**A30 Chiverton to Carland Cross  
TR010026**

**8.21 RESPONSES TO THE EXAMINING  
AUTHORITY'S SECOND WRITTEN  
QUESTIONS**

- 1.1.1 This document provides the Highways England (the Applicant) written responses to the Examining Authority's second written questions issued on 21 May 2019. It is submitted at Deadline 5 of the Examination of the A30 Chiverton to Carland Cross scheme. These can be found in **Table 2-1** overleaf.

Figure 8 Species composition for fish captured at Site 12.1

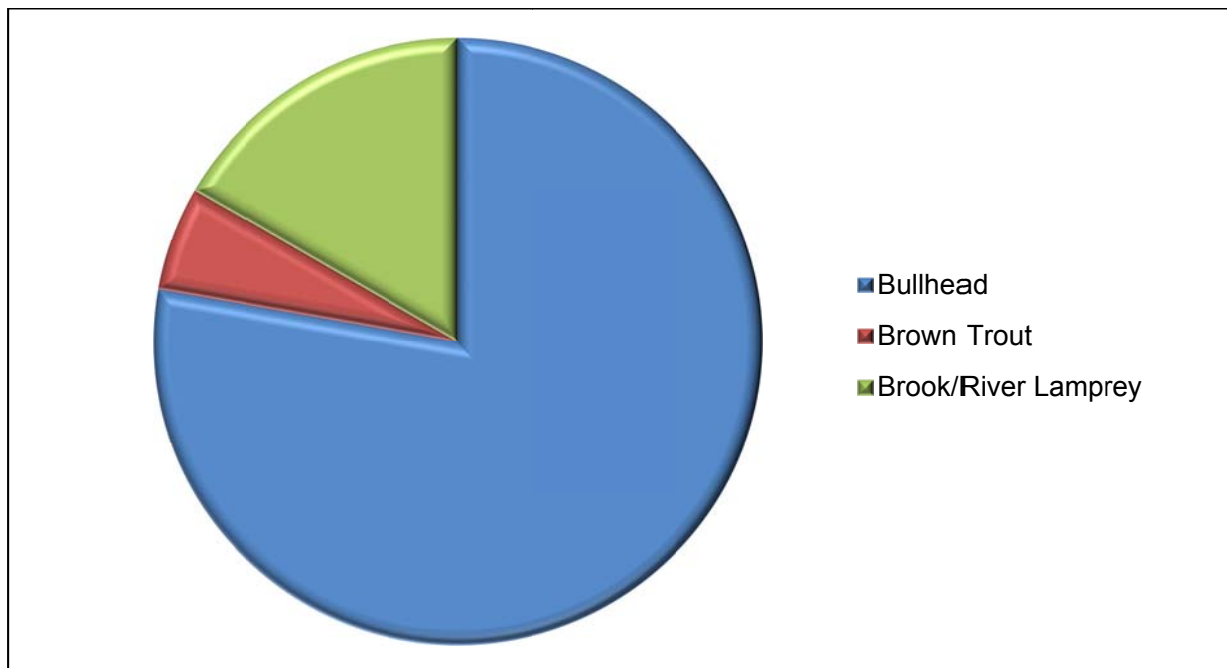
2.2.4	Applicant	Paragraph 8.10.65 of ES Chapter 8 [APP-061] states that where instream works are unavoidable, consultation	As detailed in the response to Question 2.12.1, only one headwater stream with fish recorded would require in stream works, a tributary to the River Allen, located south east of Zelah (Site 12.1) as shown in <b>Appendix 8.10 – Fish</b>

Number	Directed to	Question	Applicant's Response
		with the appropriate conservation bodies should be ensured to minimise any impacts. Can the Applicant explain if the measures necessary to reduce impacts are agreed and detailed within the CEMP?	<p><b>Survey</b> Report of the Environmental Statement (Document Reference 6.4) [APP340].</p> <p>The measures necessary to reduce impacts are currently detailed within Annex H: Outline Pollution Prevention and Control Management Plan of the <b>Outline CEMP Annexes</b> (Document Reference 6.4(A)) [REP3-014] as updated at Deadline 3 (24 April 2019). Further details have been provided within the updated CEMP Annex H relating to instream pollution and sediment prevention and control, as stated below:</p> <p><i>“Through the preliminary pollution risk assessment, any construction activity which may result in a change of aquatic conditions downstream will be designed to include prevention and control measures. This will include all instream works but may also include works close to watercourses.</i></p> <p><i>Appropriate precautions will be taken when working instream, or adjacent to, watercourses; to appropriately manage the potential for deposition of silt or release of other forms of suspended material or pollution within the water column. All measures will be in line with the requirements set out within the EA’s General Guide to Prevention of Pollution (PPG1), Works and maintenance in or near water (PPG5) and Maintenance of structures over water (PPG23) and Control of water pollution from construction sites CIRIA 532.</i></p> <p><i>Instream prevention and control measure to reduce or avoid sediment ingress into the watercourse, include (but not exclusively):</i></p> <ul style="list-style-type: none"> <li>• <i>Avoiding instream activity during wet weather,</i></li> <li>• <i>Stilling ponds,</i></li> <li>• <i>Sediment absorbent matting, and</i></li> <li>• <i>Bank reinstatement / stabilisation.”</i> <p>At the detailed design stage, these prevention and control measures would be developed and agreed with the Environment Agency as part of the required consent for the works and in line with the CEMP under Requirement 3 of the <b>draft DCO</b> (Document Reference 3.1(E)). The relevant consent to be attained is stated as <i>“Consent(s) from the Environment Agency to catch fish (using means other than rod and line) pursuant to section 27a of the Salmon &amp; Freshwater Fisheries Act 1975”</i> in <b>Details of Other Consents and Licences</b> (Document Reference 7.2) [APP-046].</p> </li></ul>
